KITITAS COUNTY

MEMORANDUM

TO: All Staff
FROM: Public Works Plan Review Team
DATE: September 11, 2025
SUBJECT: ACU-25-00002 Boys & Girls Club

SEPTIC SITE PLAN

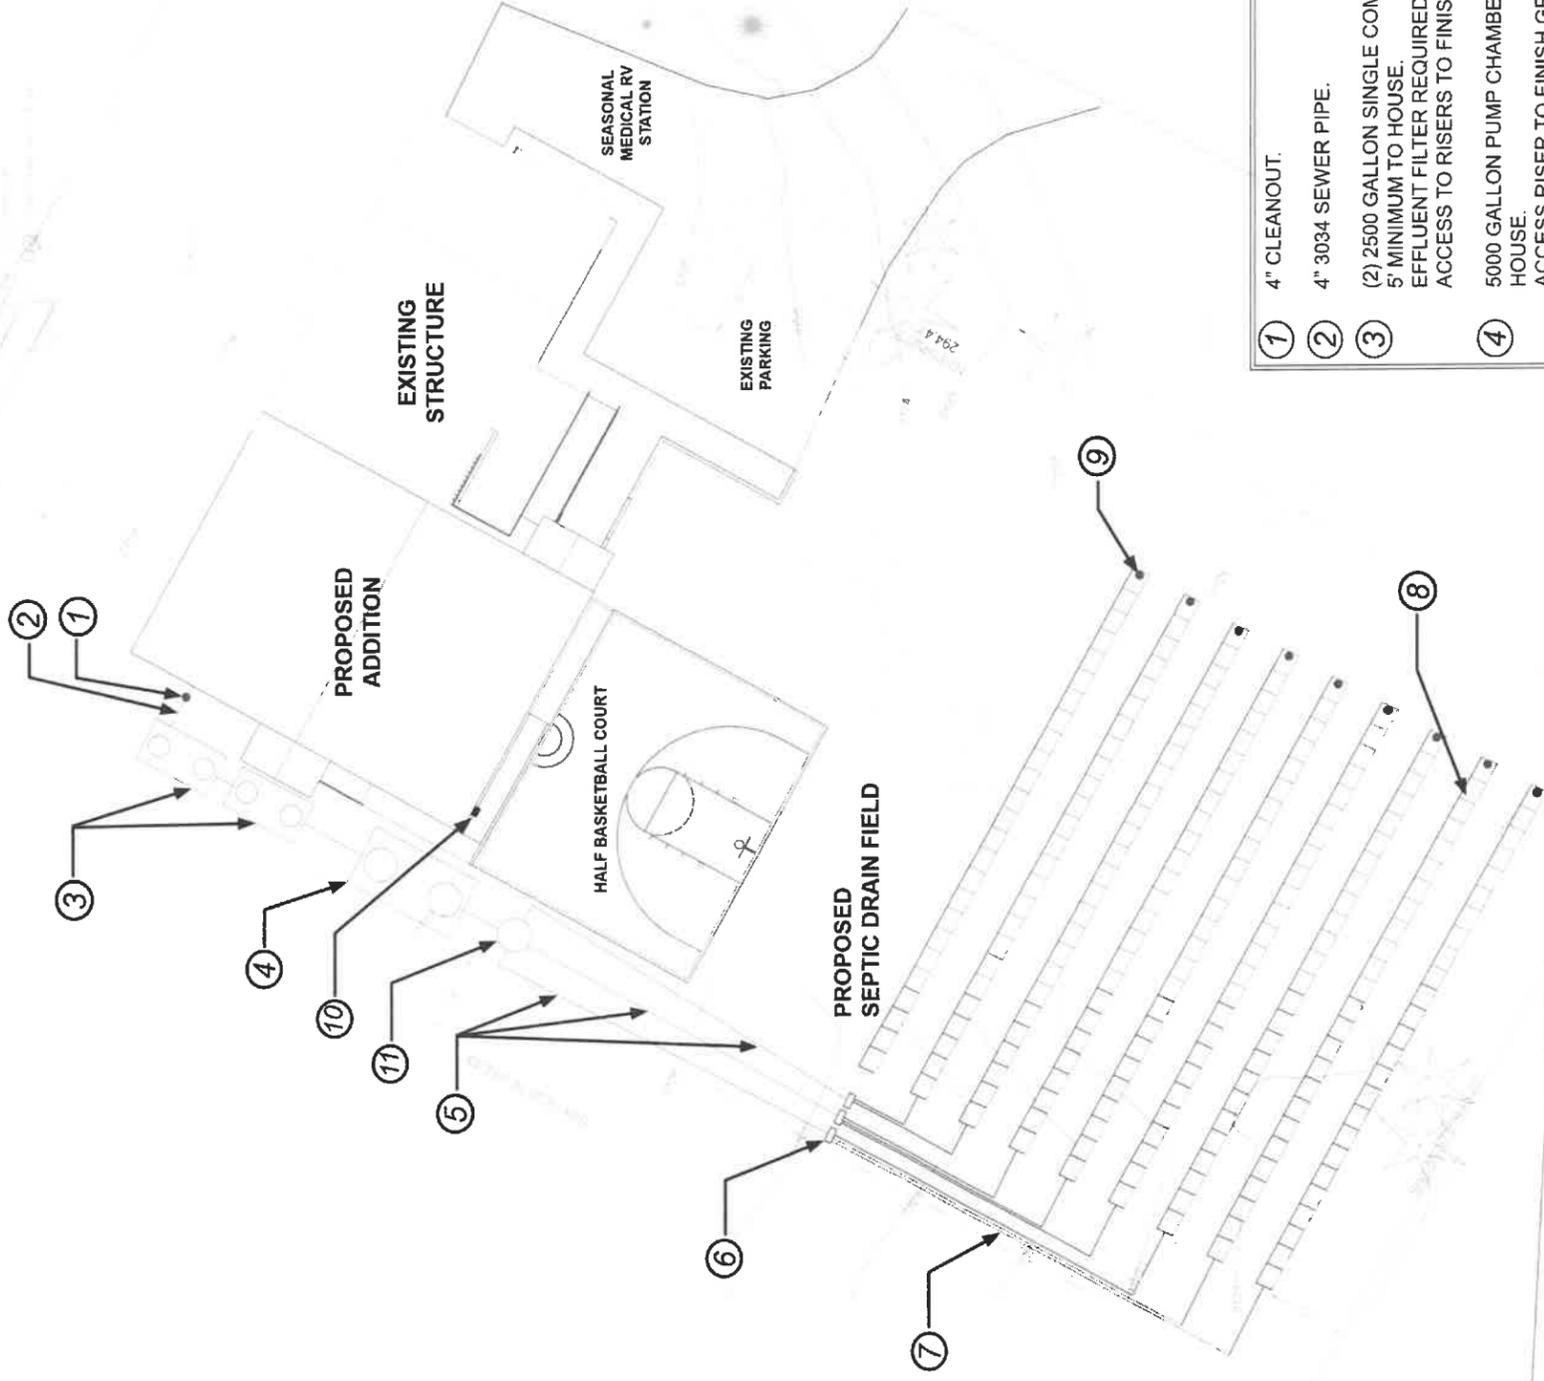
SURVEY	As the proposed site plan does not show property boundary lines, and the development proposal appears to be quite tight to fit on the existing property, applicants are reminded that they must adhere to setback requirements. It is strongly recommended a land surveyor be utilized to ensure that the proposal does not encroach or trespass onto adjacent parcels. (JT)
TRANSPORTATION CONCURRENCY	Provide estimated traffic counts for courtesy screening. Coordinate with WSDOT to identify additional concurrency requirements
FLOOD	No comments. (SC)
WATER MITIGATION/ METERING	No comments. (SC)
AIRPORT	No Comment. (RC)
